Rezoning Transportation Analysis

Petition Number: 2022-209

General Location Identifier: 12520104

Date	Description
4-27-23	First Review (PDM)
5-24-23	Second Review (DR)
6-21-23	Third Review (DR)
7-26-23	Fourth Review (JC)

RZ 1.0

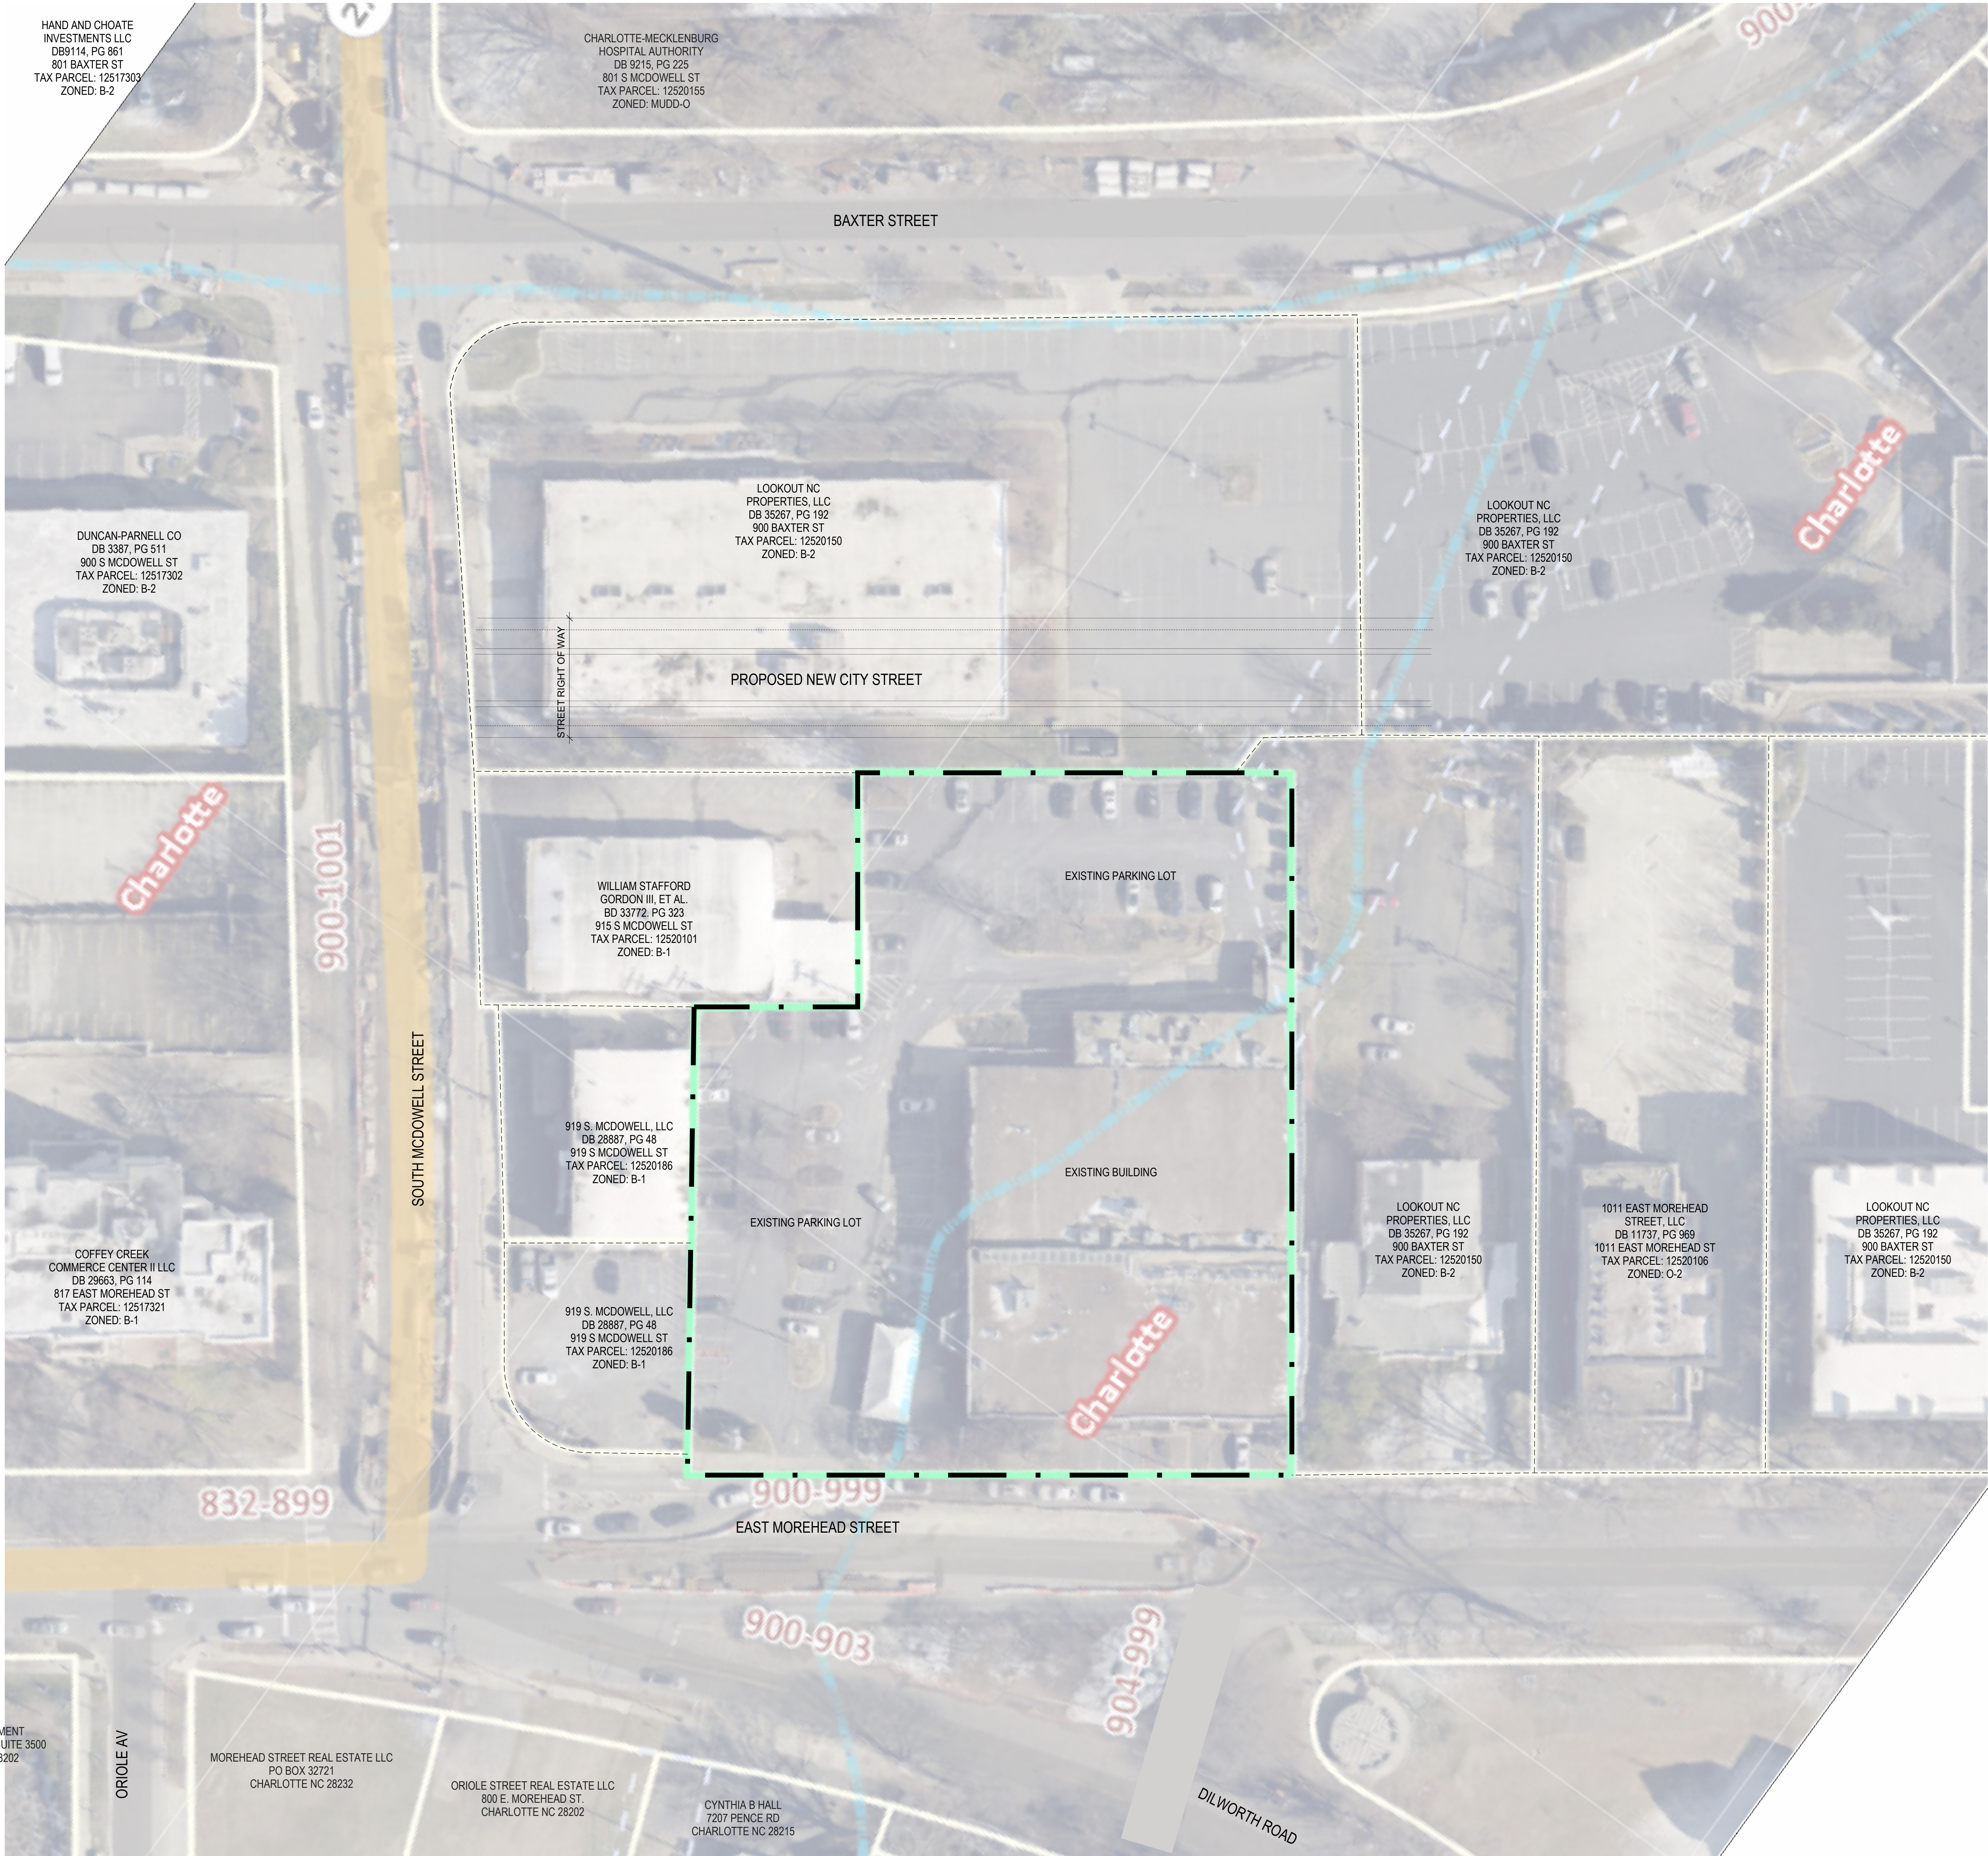
~~**Morehead Street:** Location of curb and gutter to be moved to 38 feet from roadway centerline to accommodate the Charlotte Streets Map with a roadway typical section of a four plus avenue with buffered bike lanes.~~

~~Label and dimension the curb and gutter from the centerline for each road on the site plan.~~

3. ~~Revise site plan and conditional note(s) to commit to dedicate a minimum of 40-foot of right-of-way from the road centerline. The site plan shall label and dimension the right-of-way from the road centerline. In addition, provide sidewalk utility easement if the proposed sidewalk facility will be located outside of the ROW.~~
4. ~~Revise site plan and conditional note(s) to extend the existing concrete median along Morehead to the Dilworth Road connector.~~

5. ~~Revise site plan and conditional note(s) to commit to construct an 8-foot planting strip, and 8-foot sidewalk on Morehead Street per Chapter 19. The site plan shall label and dimension both items from the back of the future curb and gutter location.~~
6. ~~Revise site plan and conditional note(s) to clarify who is constructing the offside proposed street, and that a cross access easement is required to access the street across private property.~~

- ~~7. Revise site plan and conditional note(s) to commit to construct bicycle facilities by locating the curb and gutter 38 feet from the center line to meet the Council-adopted Charlotte BIKES Policy.~~

due to the site's trip generation and location along a high injury network roadway. A traffic study for the site was approved on 6-21-23. All outstanding CDOT comments have been addressed.
